Rezoning Transportation Analysis

Petition Number: 2022-133

Revision Log:

Date	Description
1-25-23	First Review (TM)
2-22-23	Second Review (TM)
04-26-23	Third Review (TM)
05-11-23	Fourth Review (TM)

REZONING PETITION #2022-133

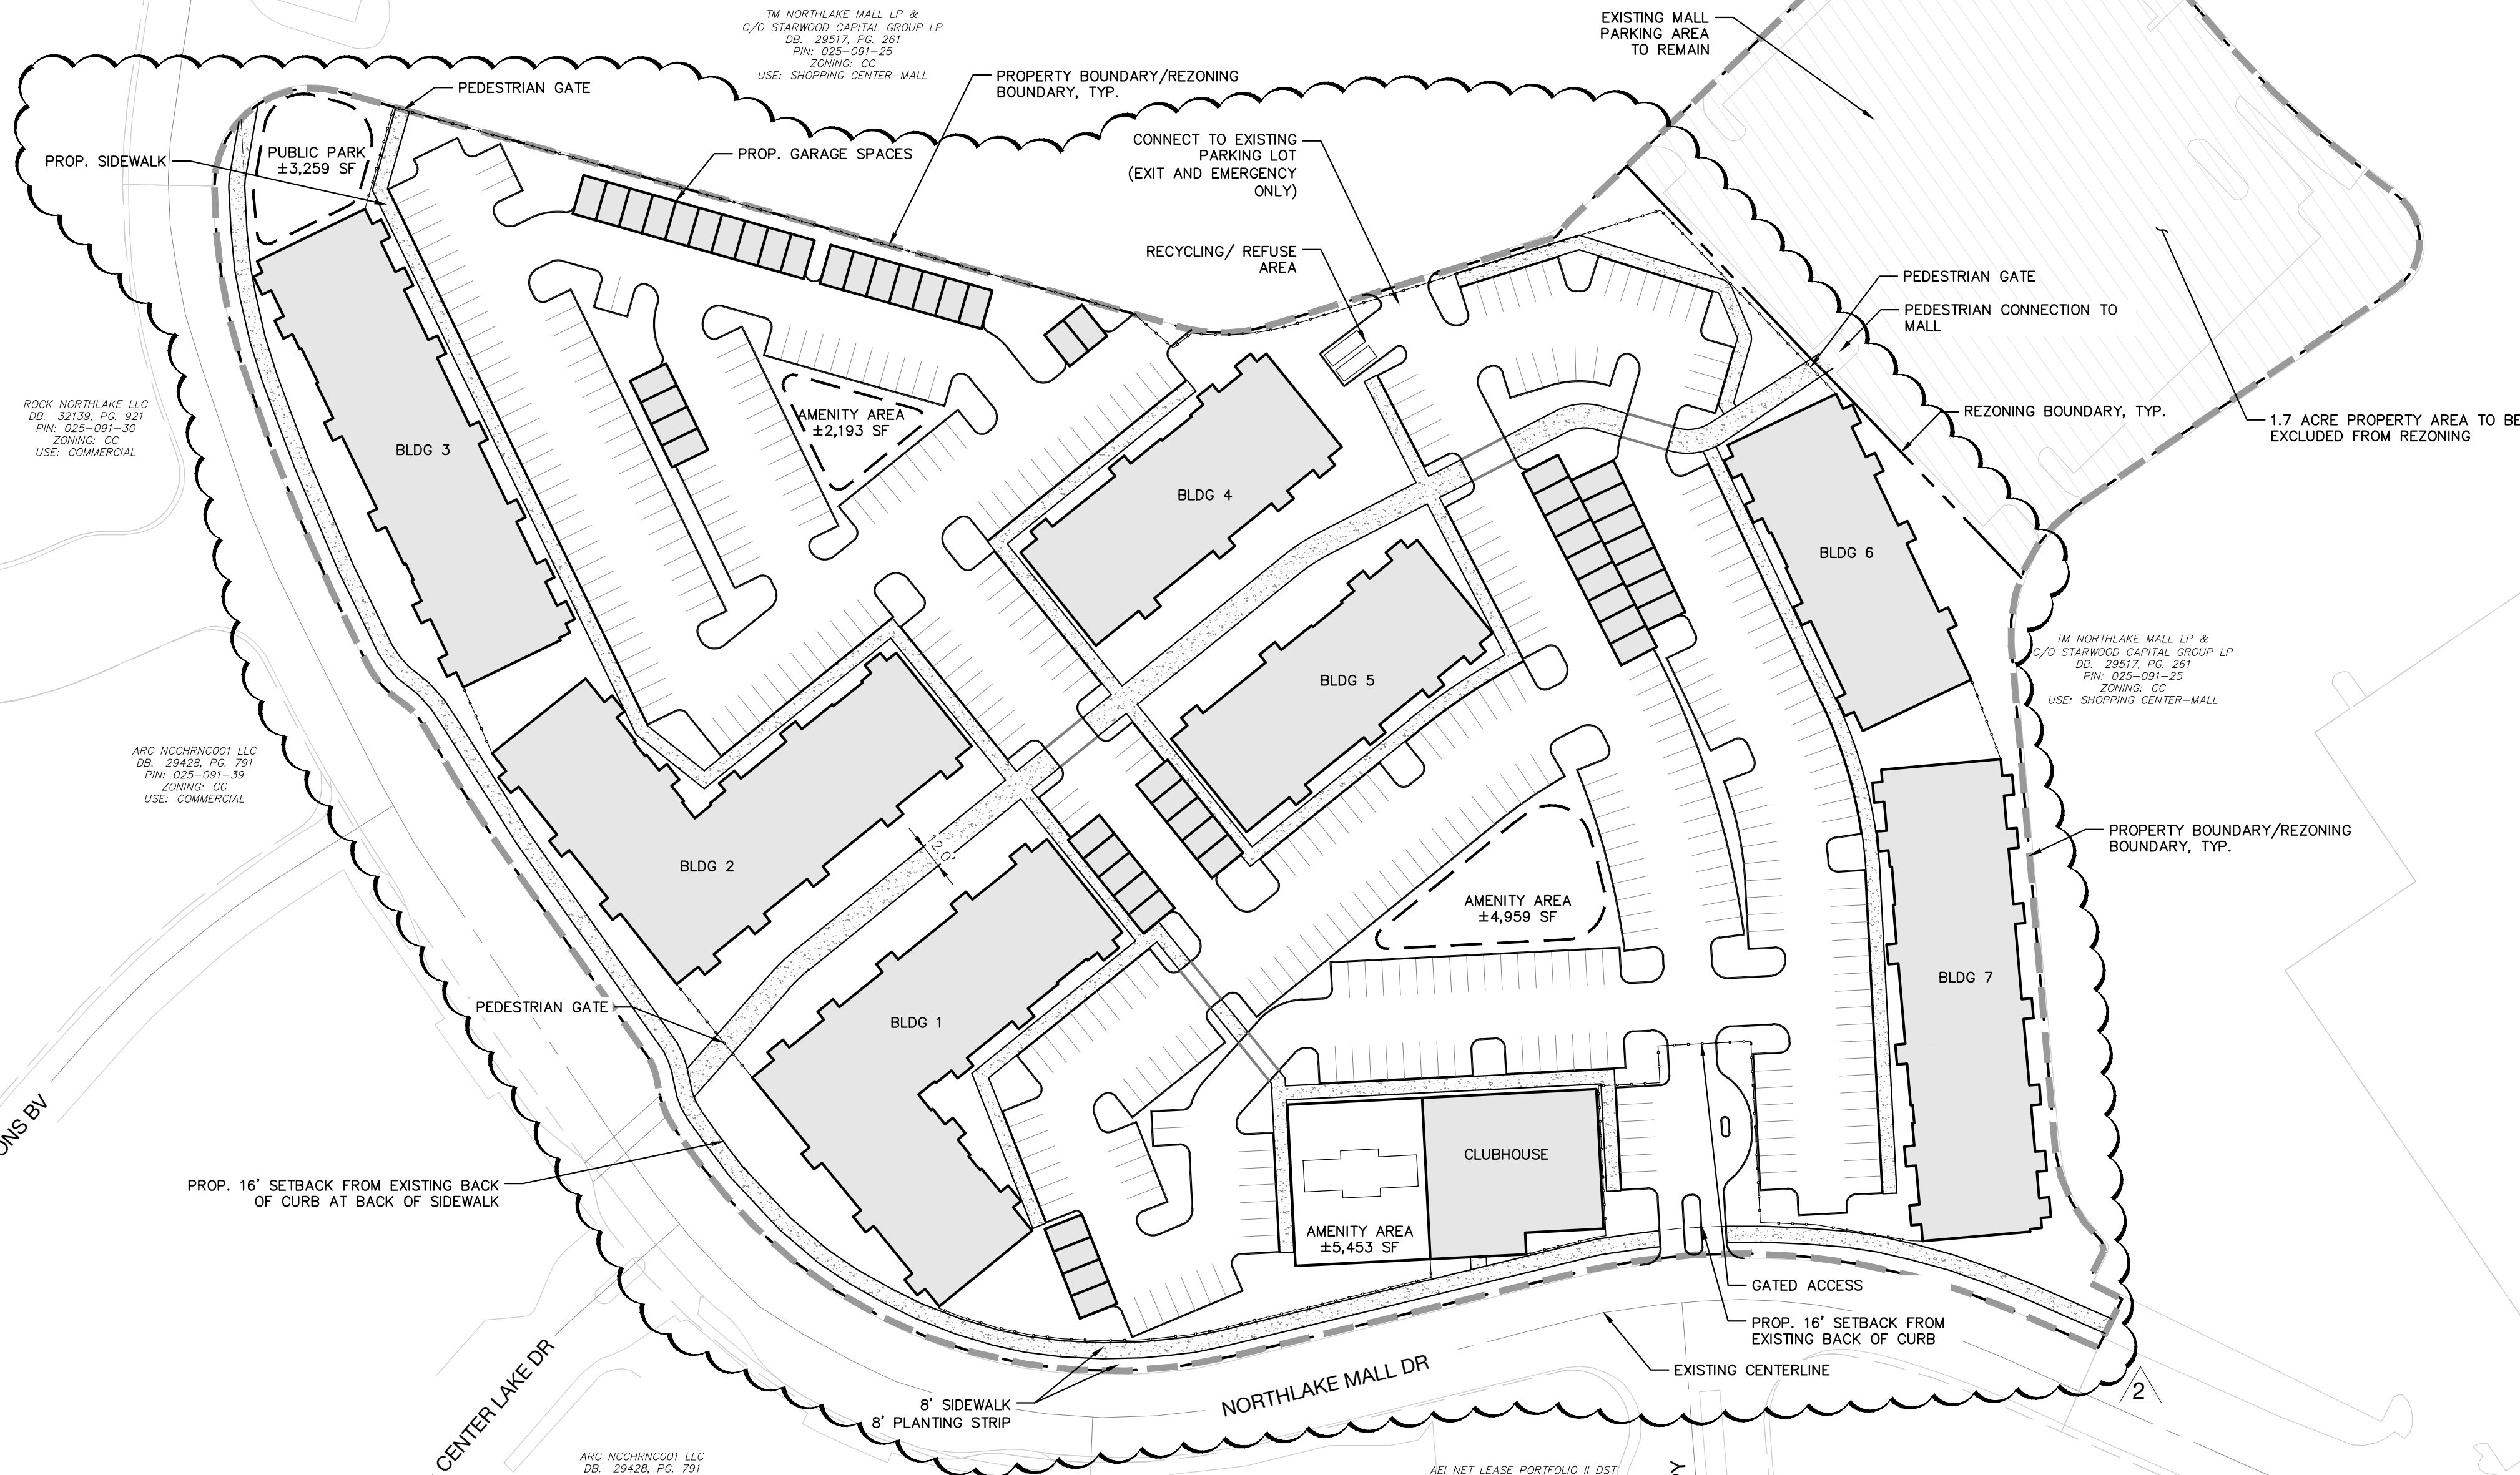
~~New Comment 04-26-2023:~~ ~~Site plan updates changed access location impacting both the TIS and the recommended improvements. Update or addendum to TIS required along with updated conditional notes to match TIS improvements.~~

# REZONING PETITION #2022-???

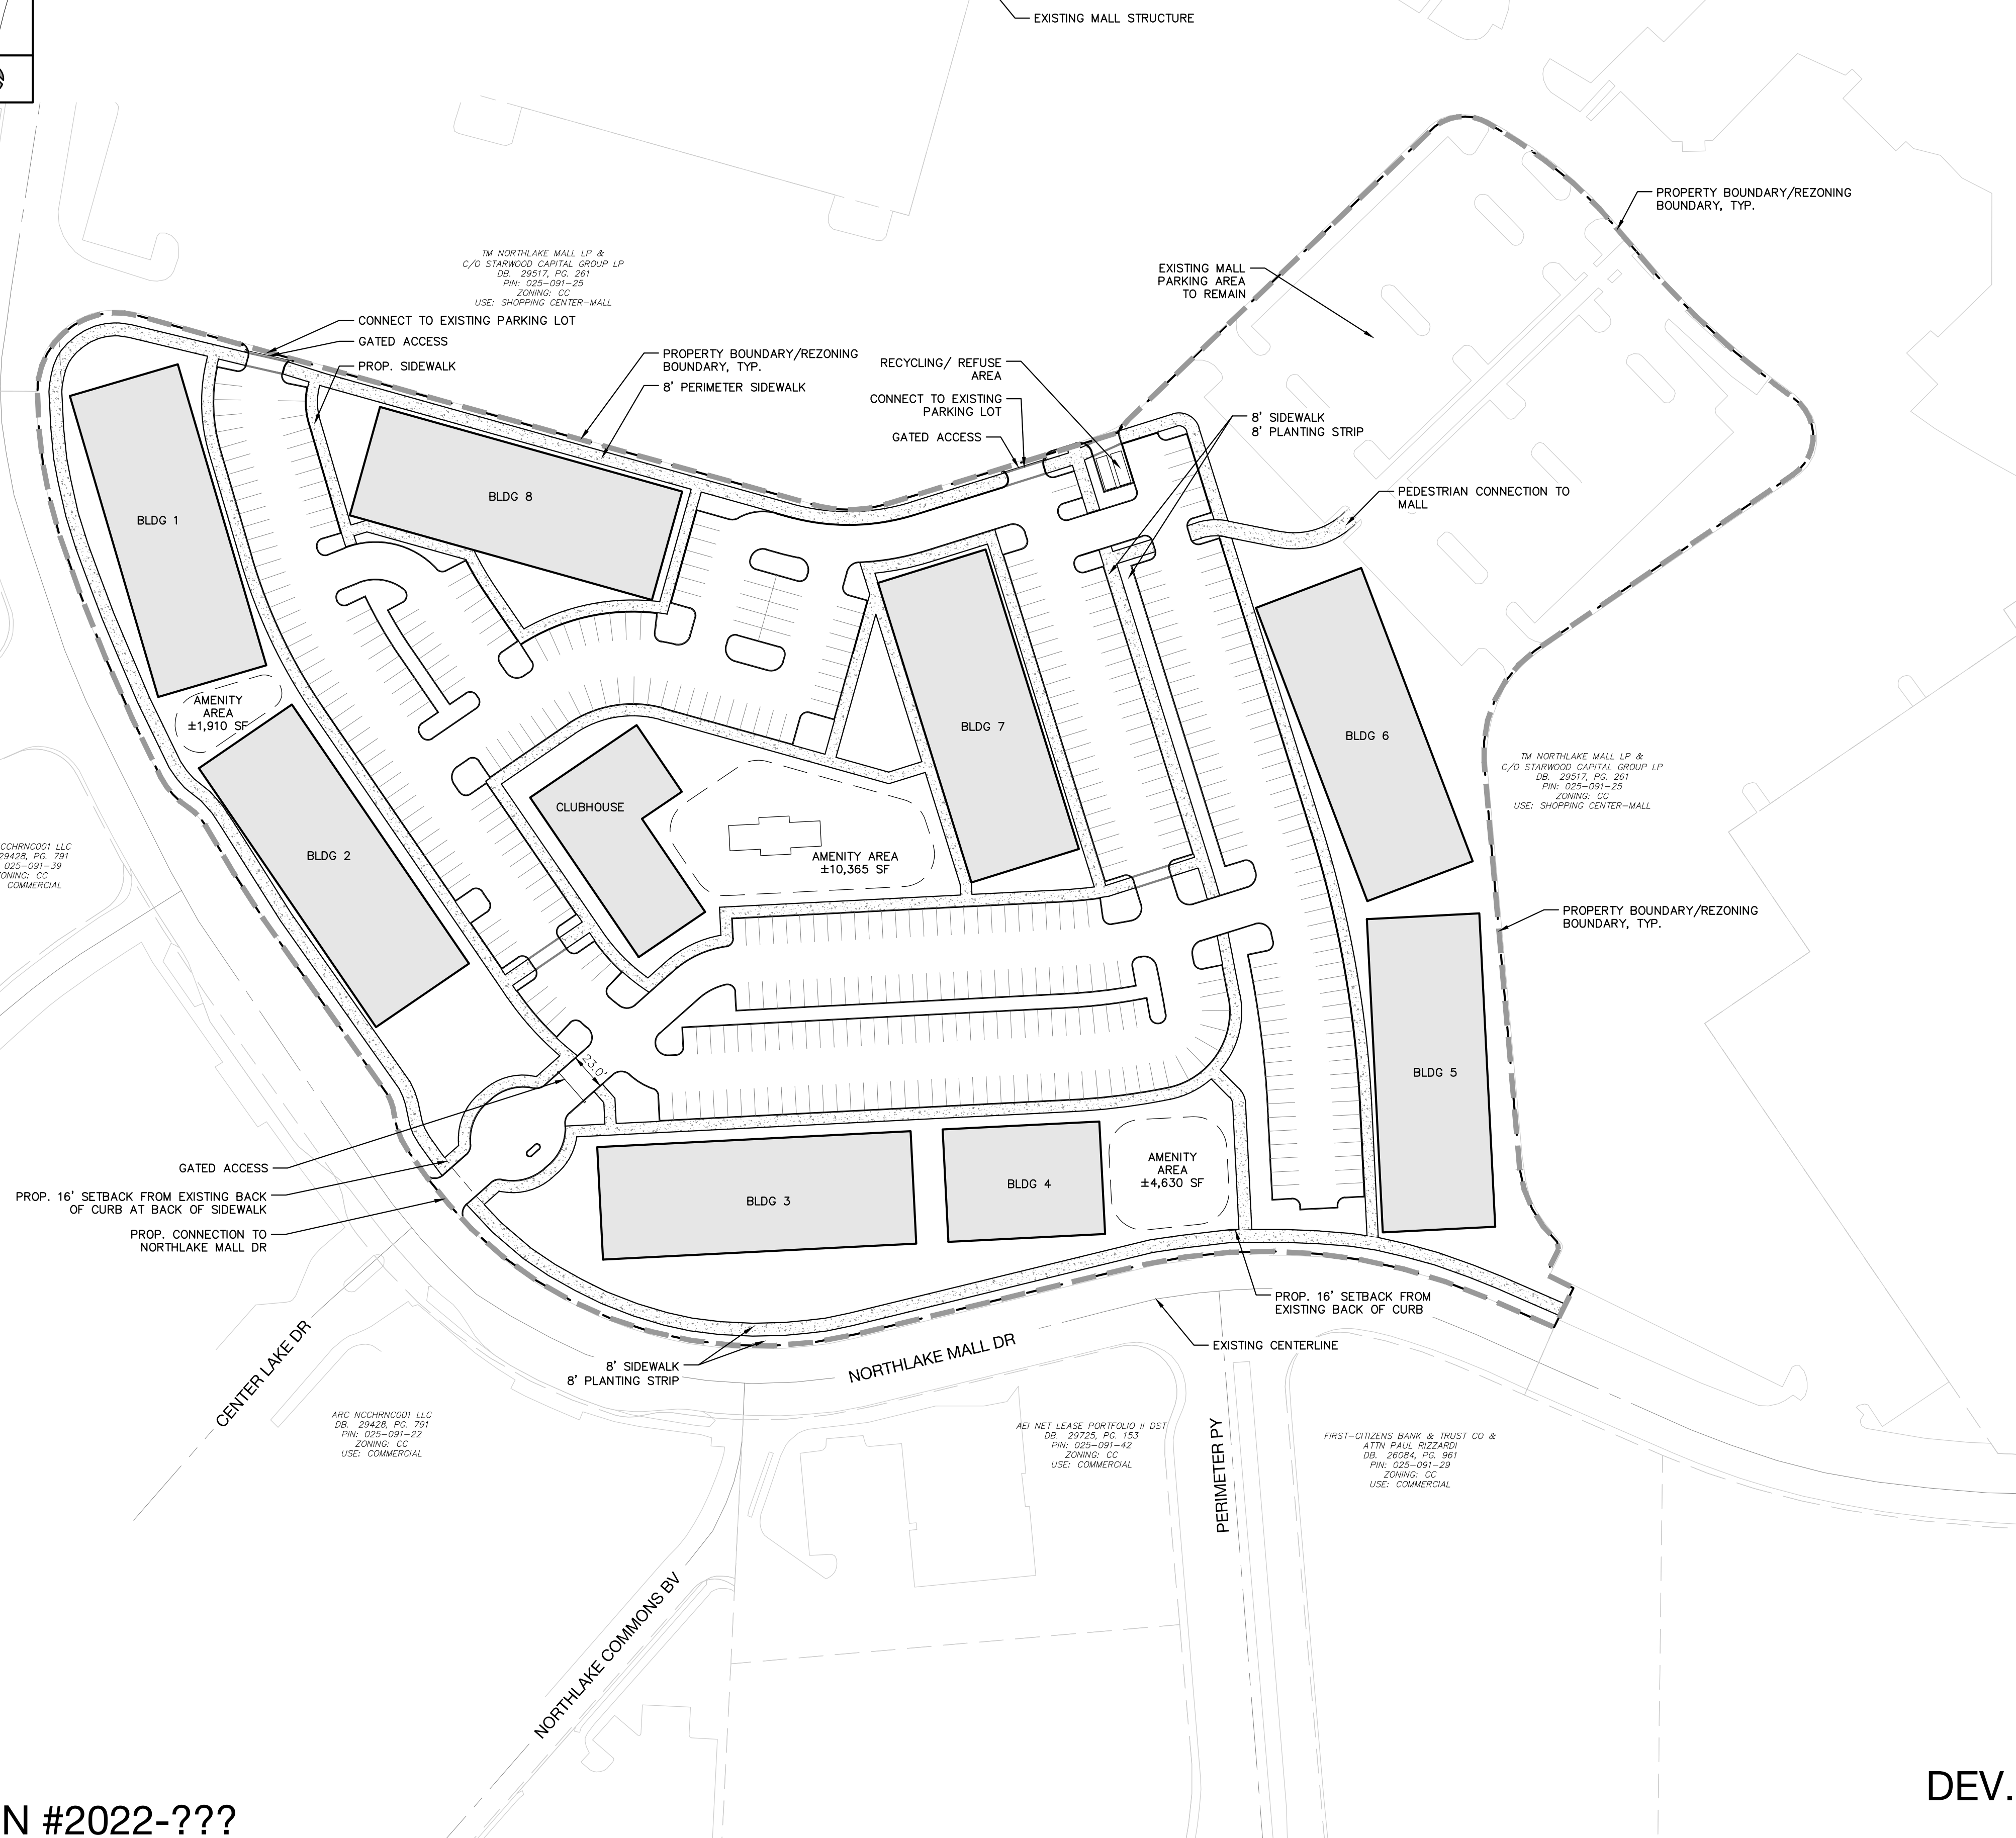
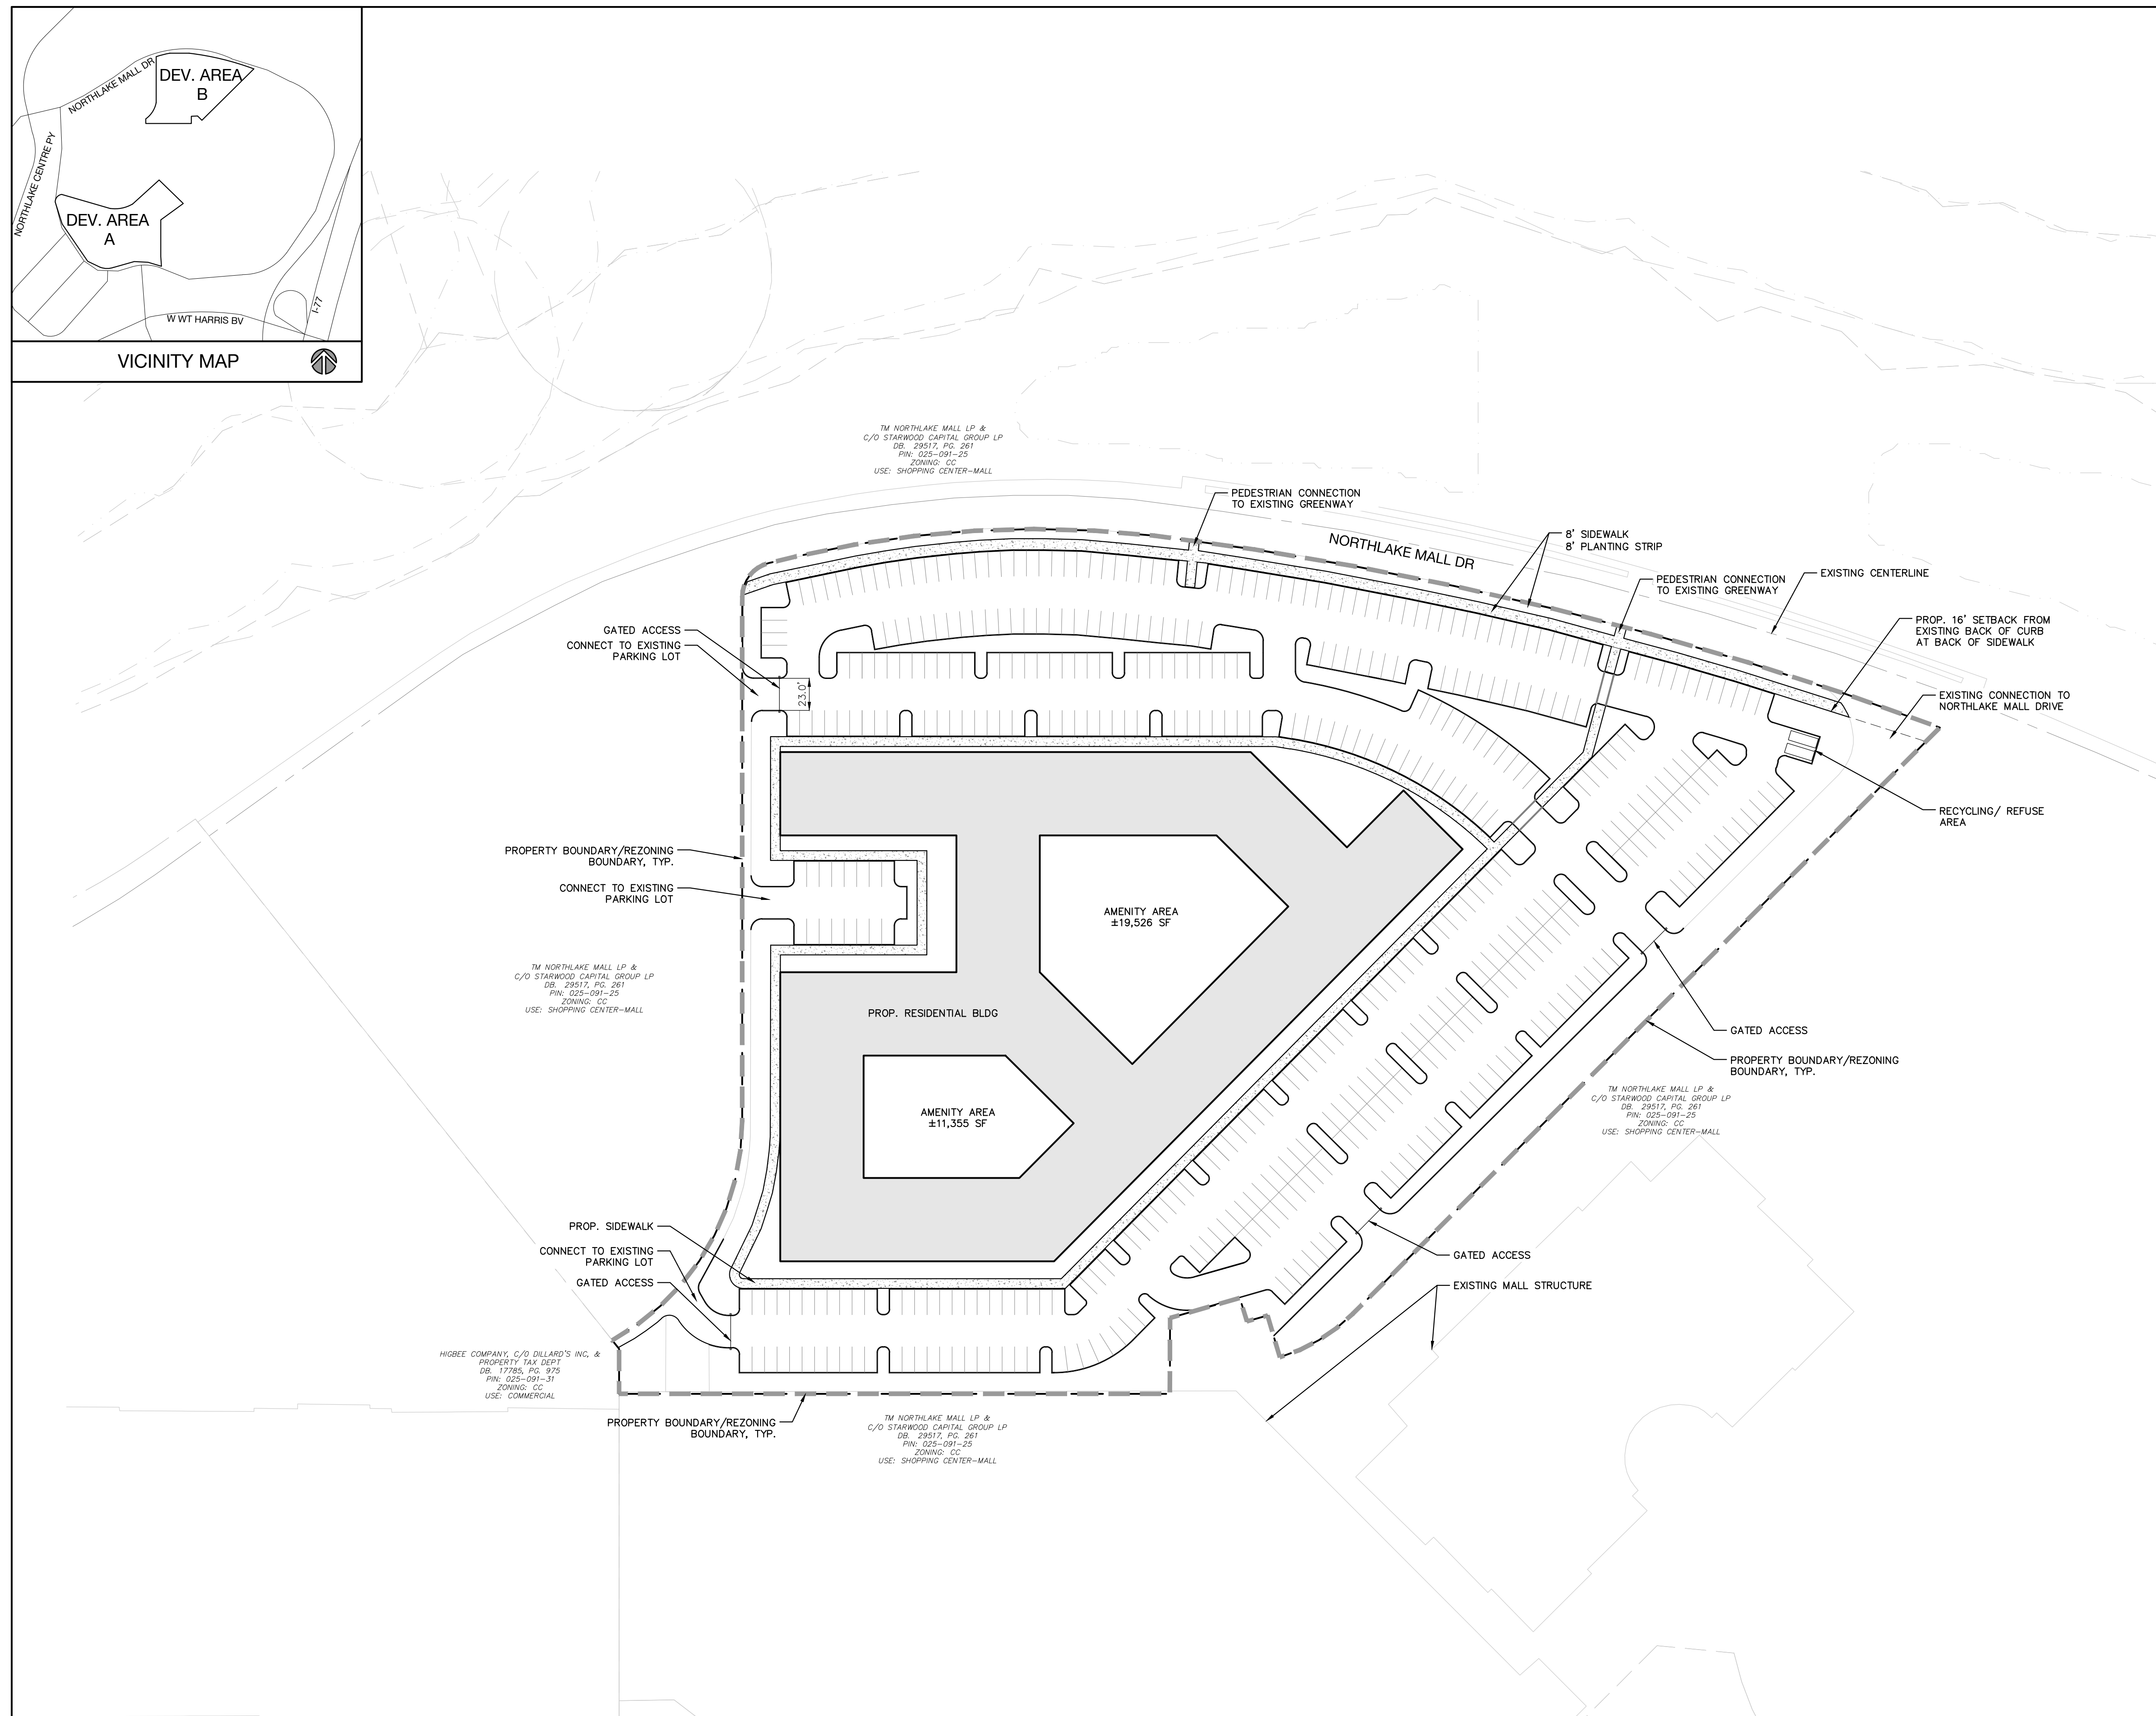
4. ~~Revise conditional note(s) by removing all references to other rezonings and filling in rezoning information in the notes.~~

Not rezoning
frontage

Fill out info

REZONING PETITION #2022-???
